1 No. two storey house (resubmission following A/87/18/PL). This application is a Departure from the Development Plan & affects a Public Right of Way.

Land between Ashurst & Badgers Ham Manor Way Angmering

Thank you for your internet representation made on 9th April 2019 which has been recorded as '**an objection**' with the comments as follows:

Drawing Title:
Proposed Plans, Elevations and Street
Scene Elevation
Drawing Number: 1202.01.c
Scale: As stated printed @ A1
Date: 06/02/2019

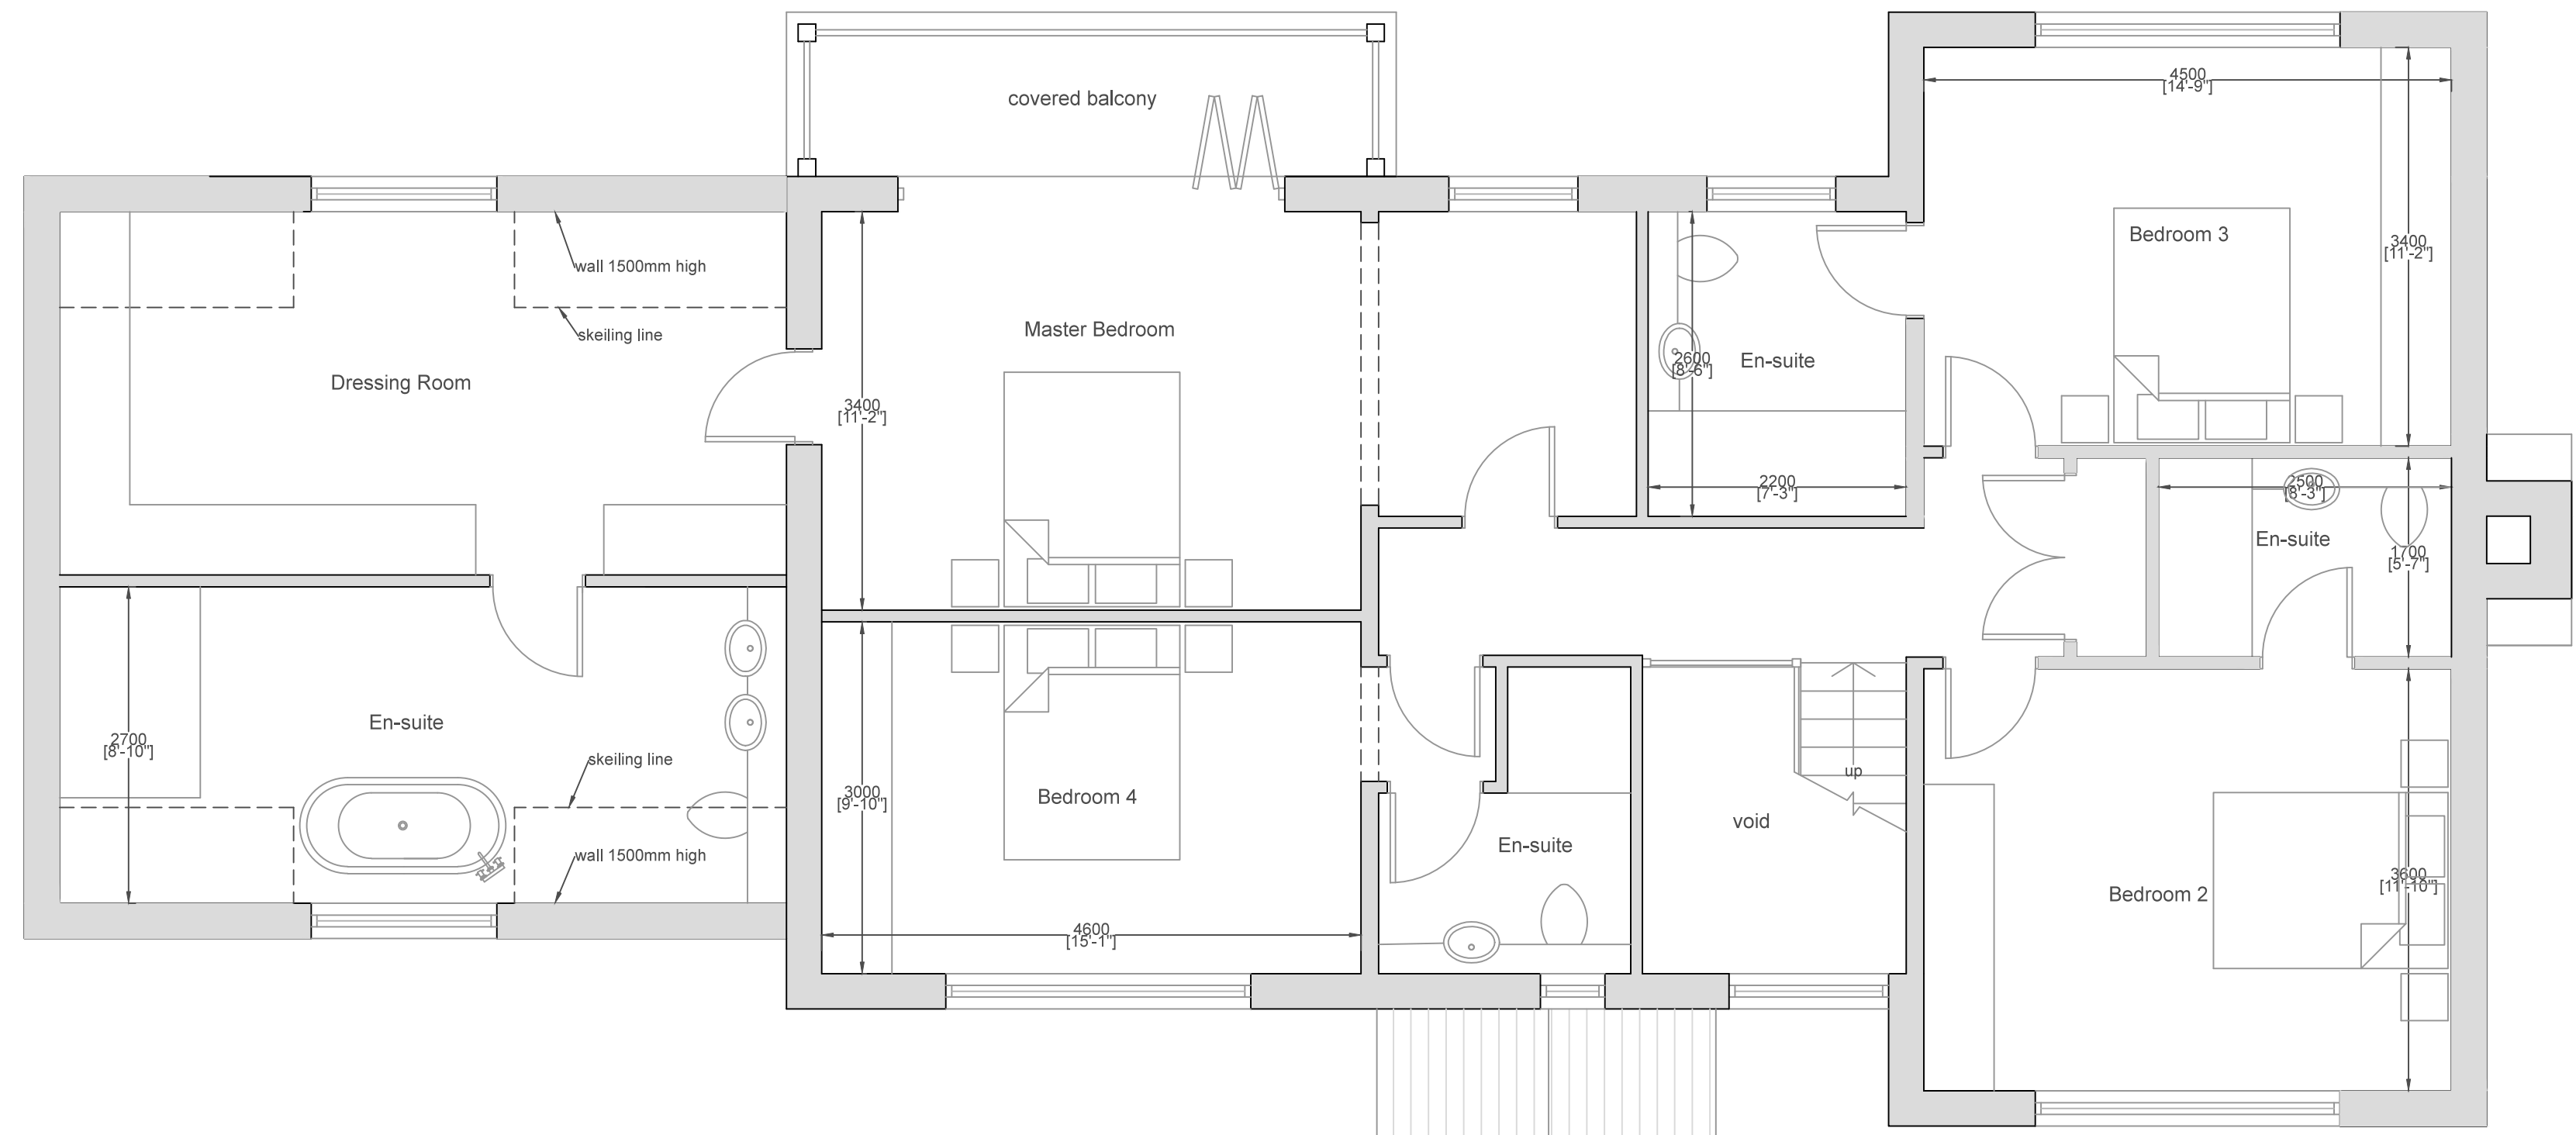
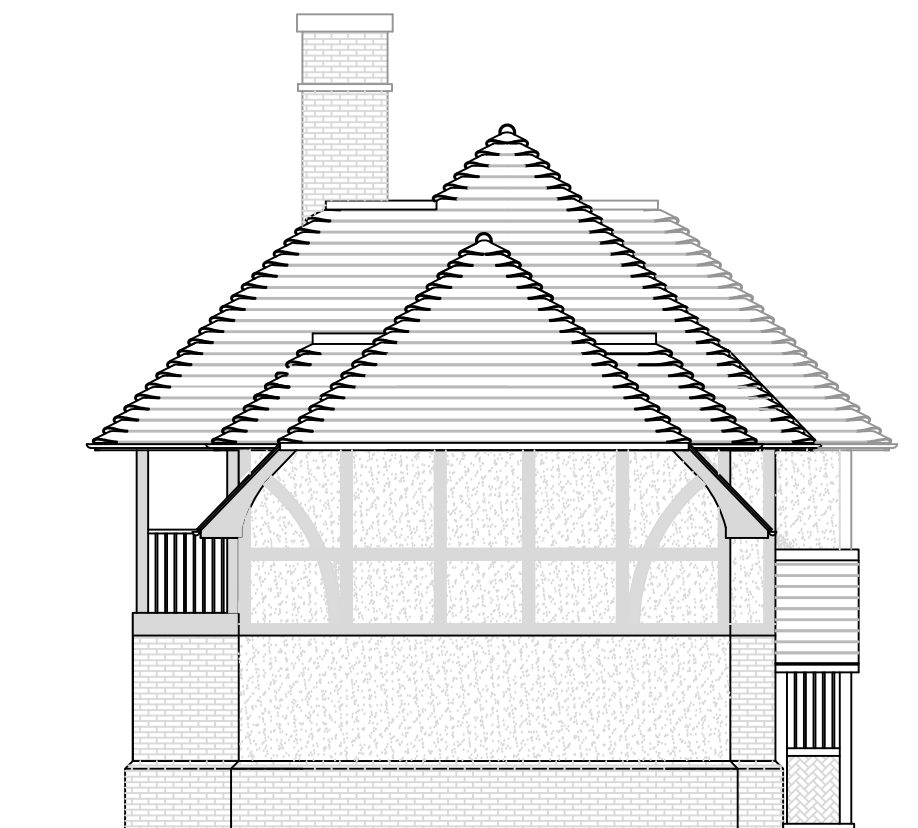
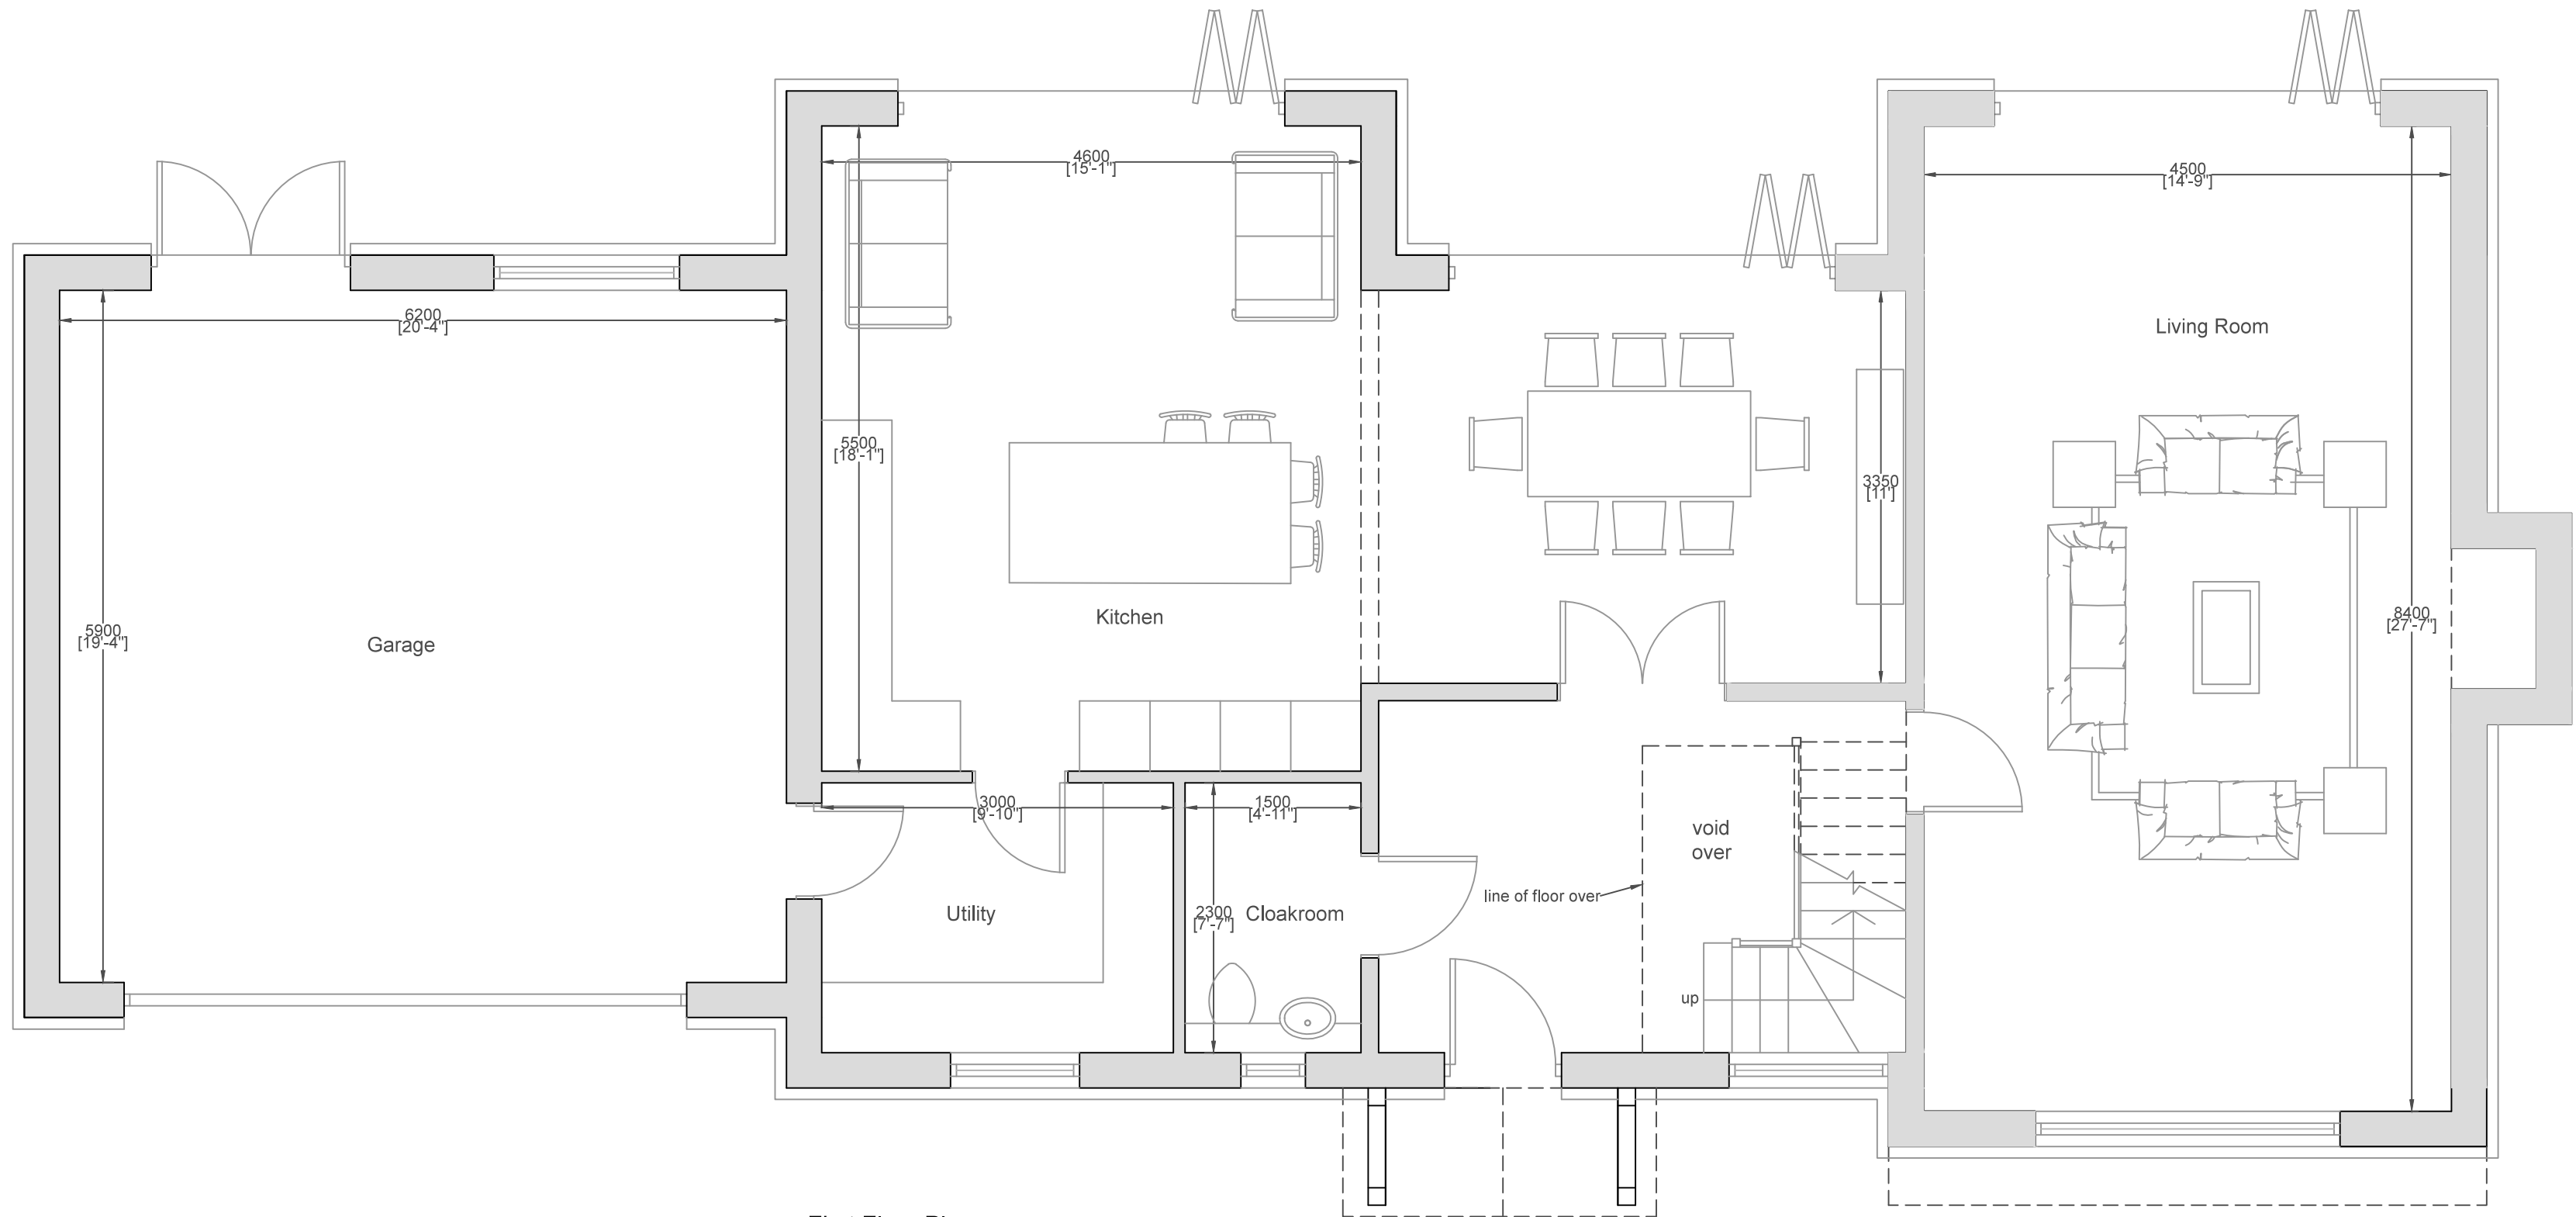
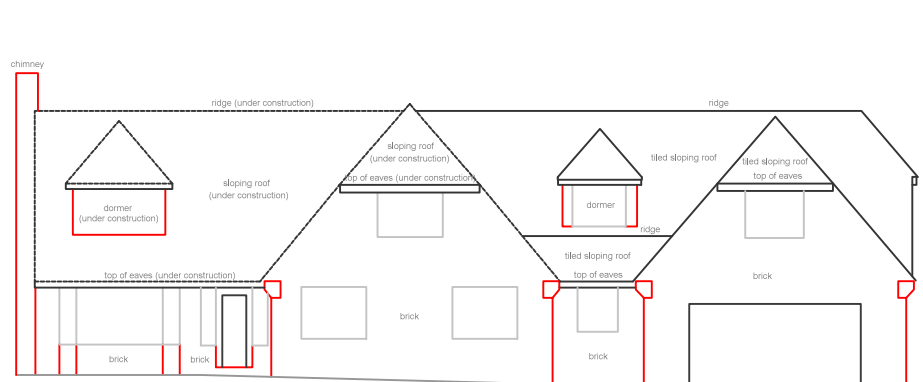
Too Big in itself for the plot size bearing in mind it's one of two units, Street scene.

In the same document under NEIGHBOURHOOD CONSIDERATION it states there are no side facing first floor windows, if planning is allowed then this should be enforced on the permission for both first floor and ground floor to prevent overlooking neighbours to the

SW and NE with a material change later.
